Application: SSI 7485

I write regarding the proposed modification to M4-M5 Link, Mod 2 The Crescent overpass and changes to pedestrian infrastructure in North Annandale, Rozelle and Rozelle Bay Foreshore area.

Figure 4-4 Elevation: Indicative view of The Crescent overpass

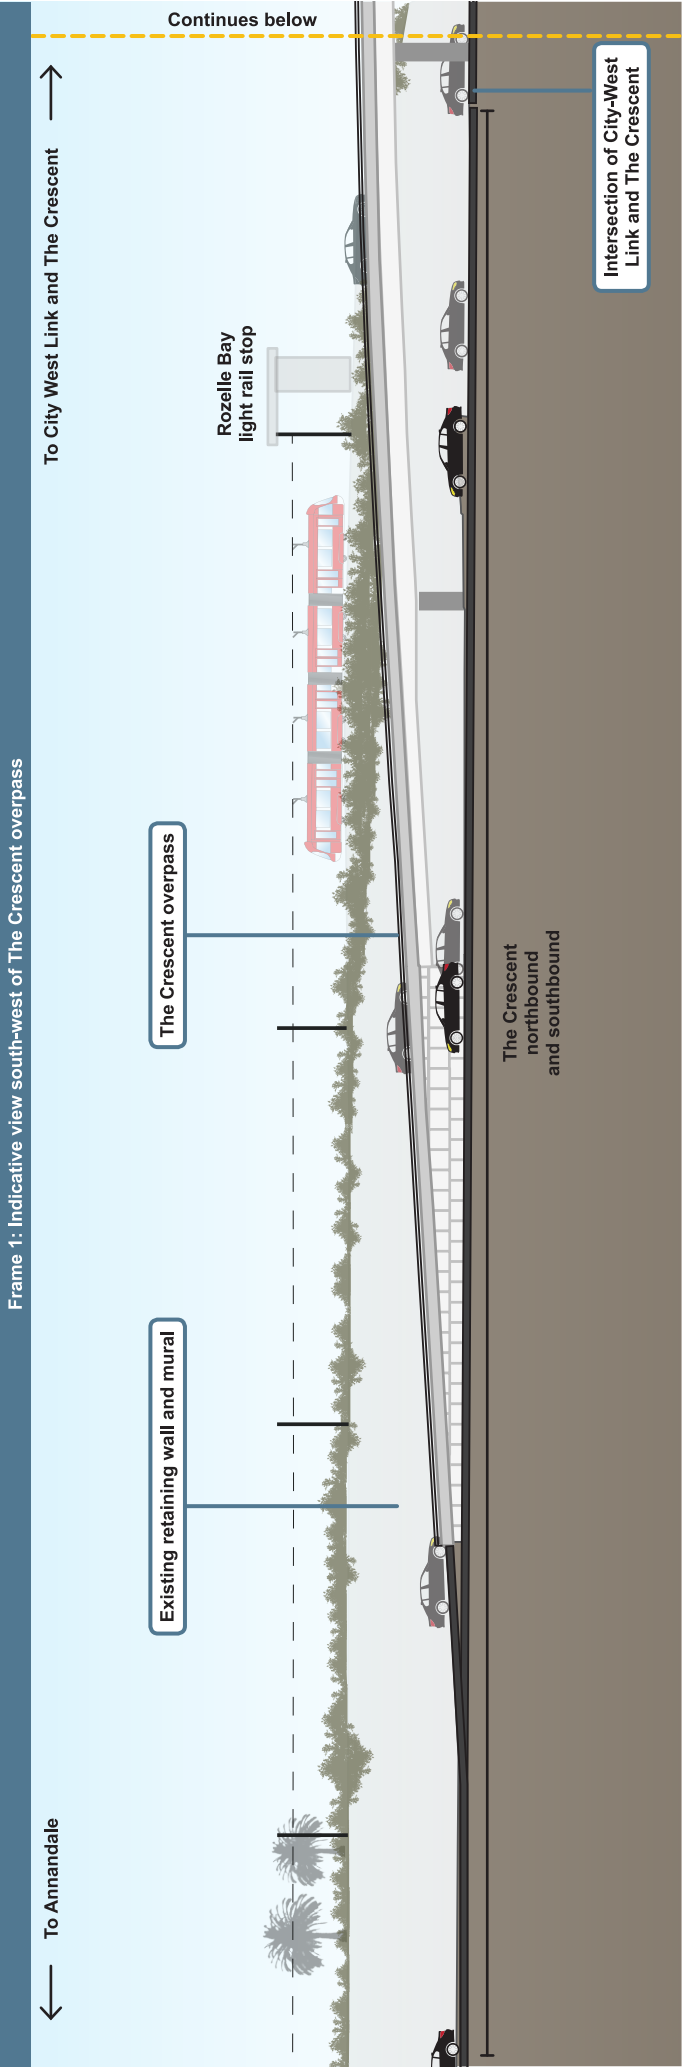
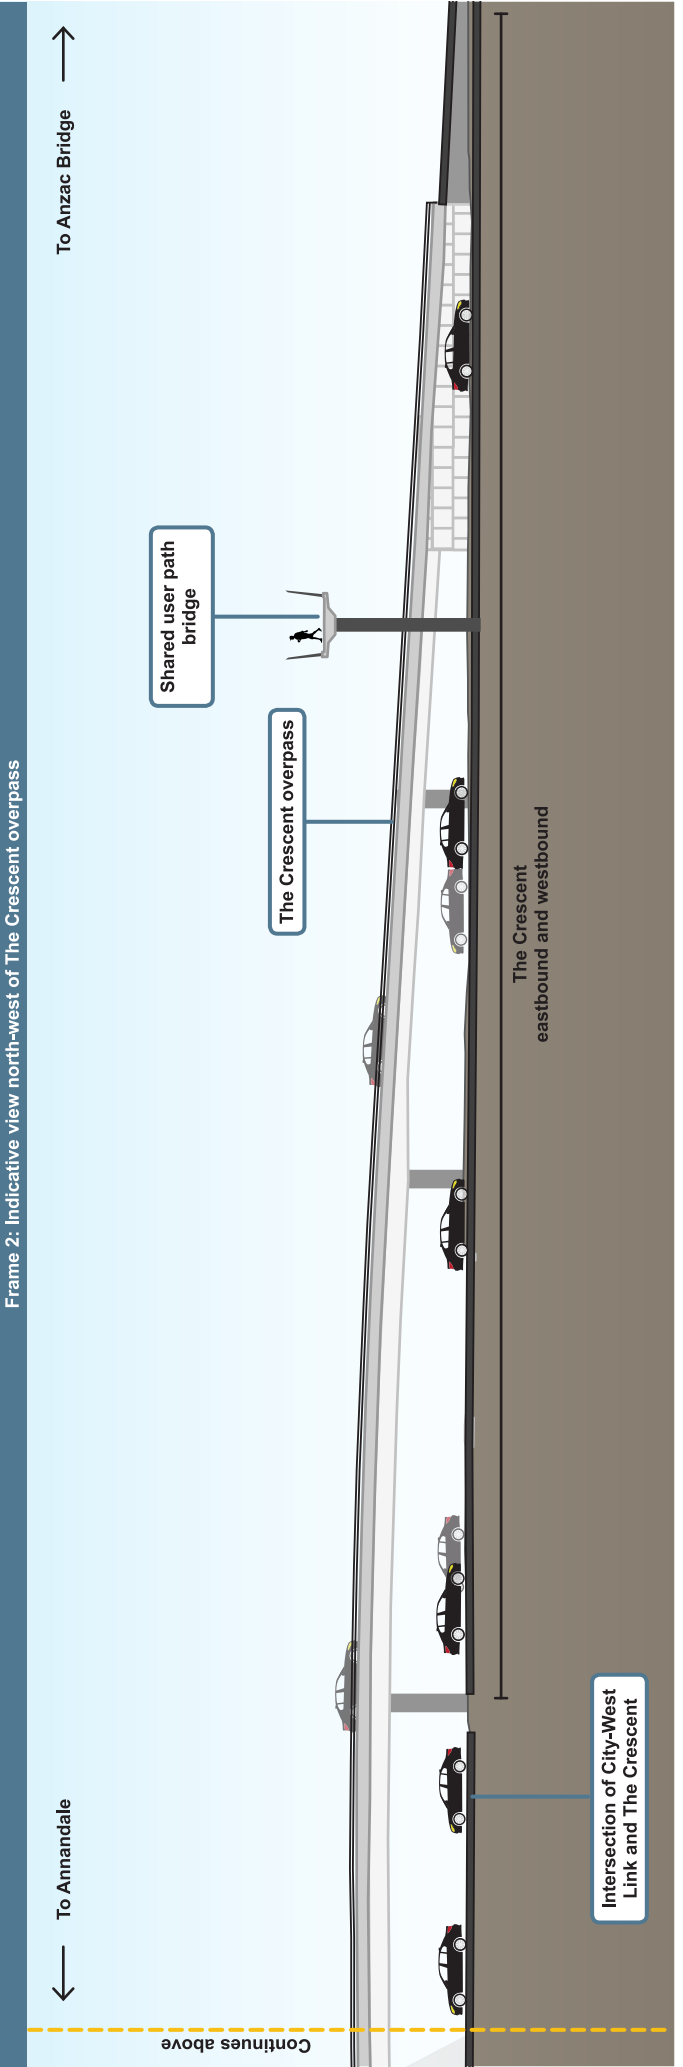
- I live on the northern end of Annandale and am extremely concerned about the traffic noise and pollution from an overpass basically level with our elevated houses, especially with so many young children in our beautiful, friendly, safe, quiet area.

- Planning long term for a beautiful and clean Bays Precinct.
- Create a safe intersection for residents, especially children, with easy access to the park and water.
- Eliminate the eyesore of an elevated ~~or~~ overpass.
- Reduce noise and pollution to North Annandale by keeping the intersection at, or below, ground level.

Figure 4-5 The Crescent/Johnston Street/Chapman Road intersection

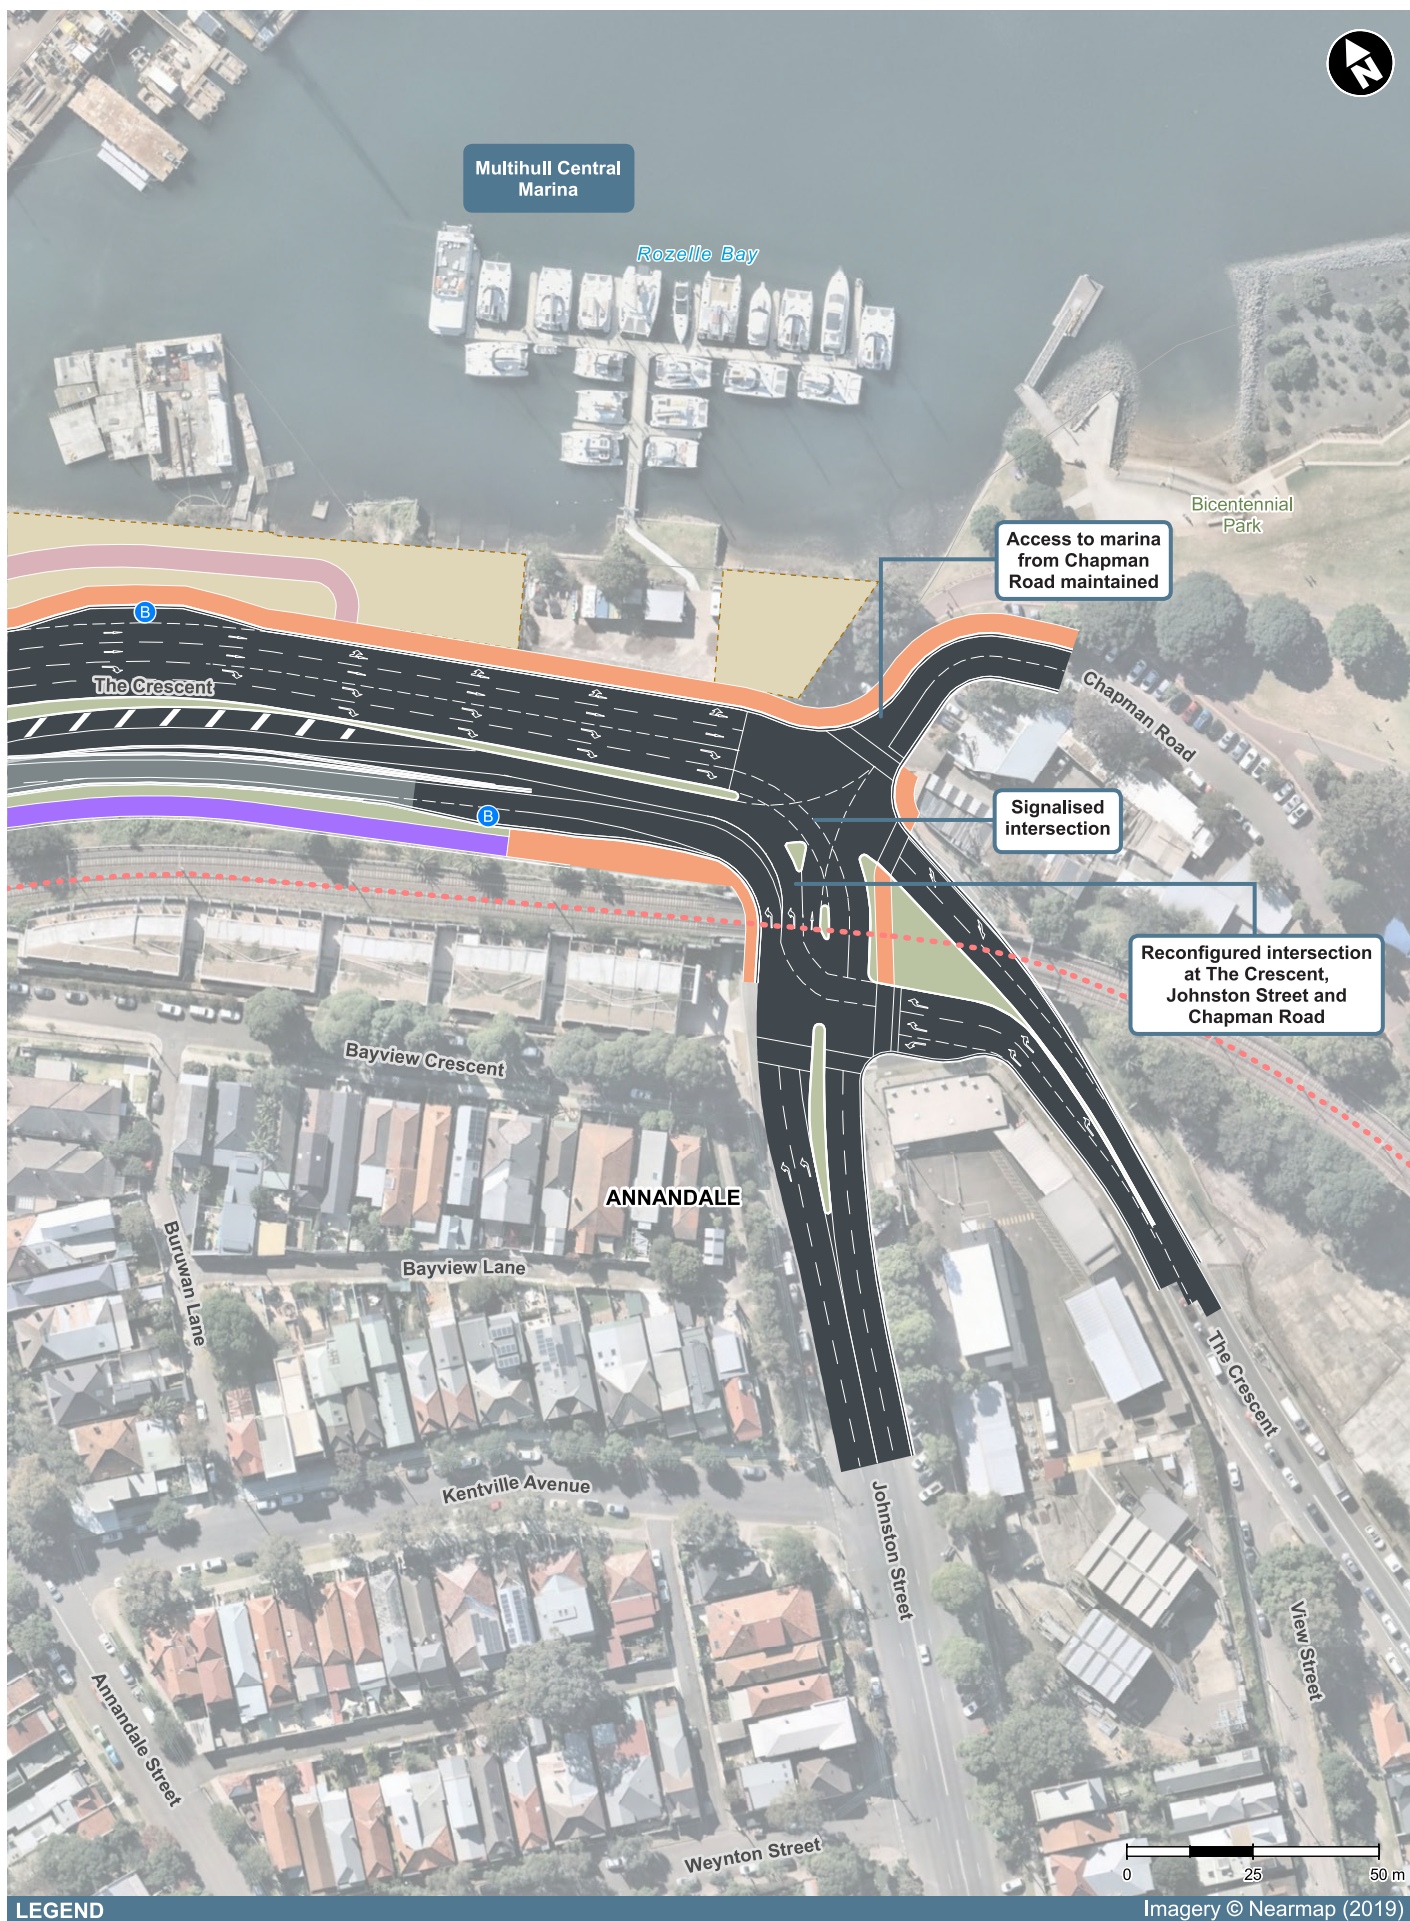
- The significantly reduced safety and increased risk for pedestrians and cyclists with removed access over The Crescent to Bicentennial Park and the increased traffic along Johnson Street.
- Being required to cross five sets of pedestrian lights at The Crescent as my option to reach the foreshore from Annandale or from Rozelle Bay light rail stop.
- Removal of direct active links to the foreshore, cutting the community off from the area and the proposed revitalisation of the entire Bays Precinct, including linking the Light Rail and Bus stops to a Ferry wharf and Metro station.
- Urban and landscape design that is being built before a finalised Masterplan for the area.
- Traffic changes that limit movements around the suburb and create further congestion in the local streets of Annandale, Forest Lodge, Glebe, Lilyfield and Rozelle with no planning to deal with these.

Figure 4-6 Elevation: Indicative view of Rozelle Rail Yards Pedestrian and Cycling Green Link

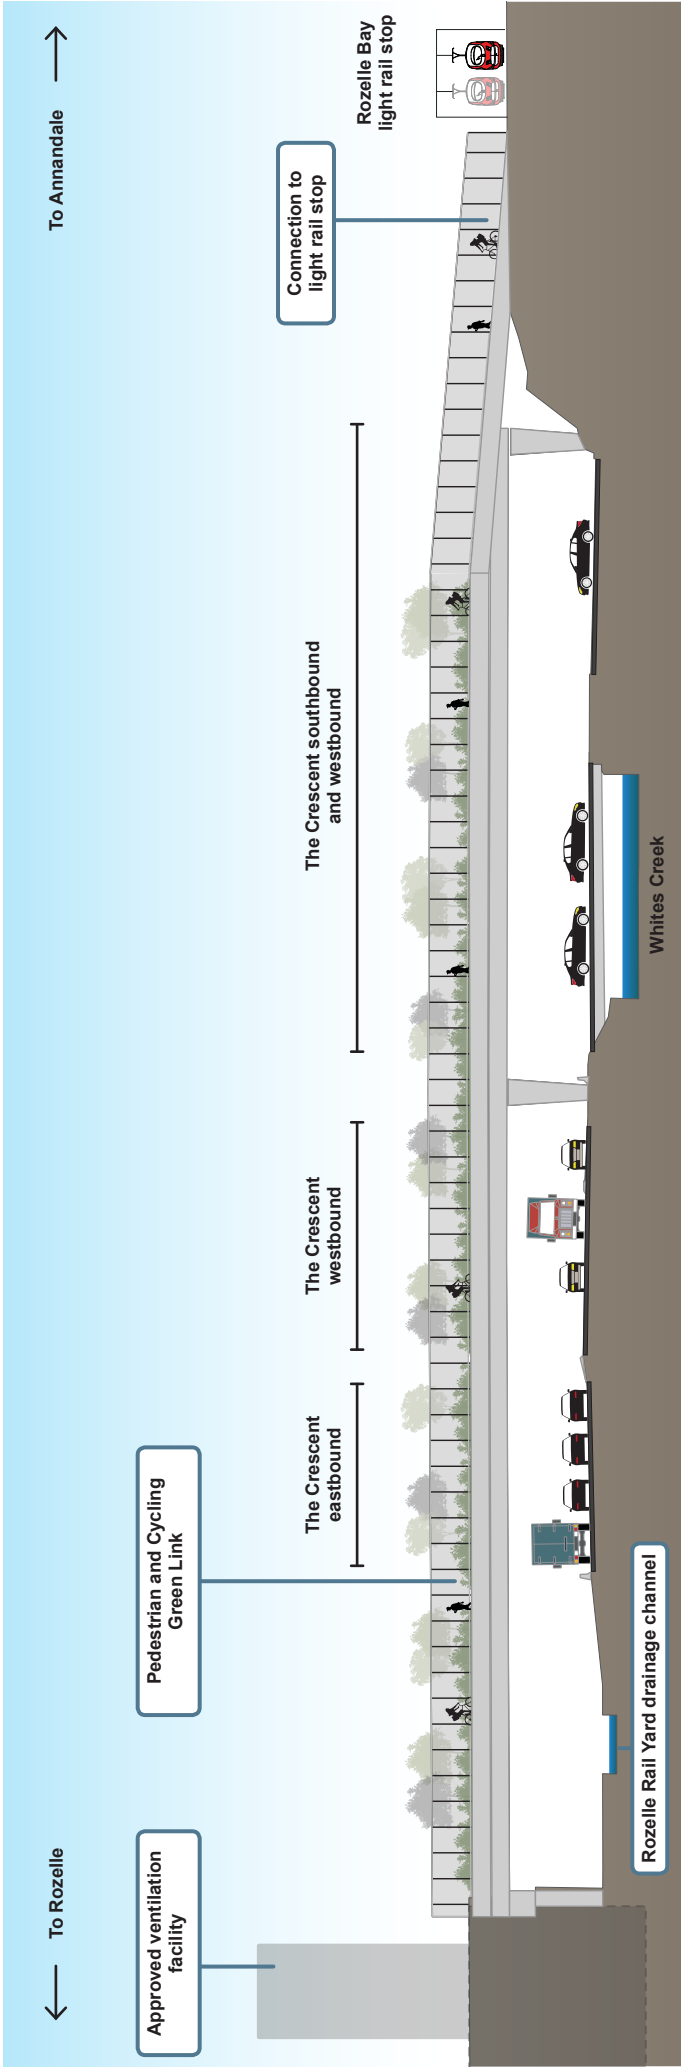
I request RMS work with the community to explore alternate design options to the proposed new car overpass design and the changed pedestrian and cyclist links. I am seeking the reinstatement of the safe, direct access from the approved EIS GreenLink to create a continuous green open space connection from the Rozelle Rail yards and Annandale to the foreshore. The GreenLink was more than just a walk way - it put people central to the design, maximising safety, and providing much needed accessible open space for the community now and into the future Bays Precinct design.

- Reinstate the GreenLink connecting communities and green open space from Rozelle to Bicentennial Park
- Relocate and design pedestrian and cyclist connections that are continuous, safe and direct.
- Design the modification infrastructure and active links in response to the character of the suburbs, the location of the foreshore and it's potential future development.
- Provide pedestrian and cyclist paths that maximise people safety and do not force them onto busier streets, unsafe concrete plazas and caged walkways.
- Integrate active and direct connections to all active transport - including the future Metro West and Foreshore Ferry Wharf
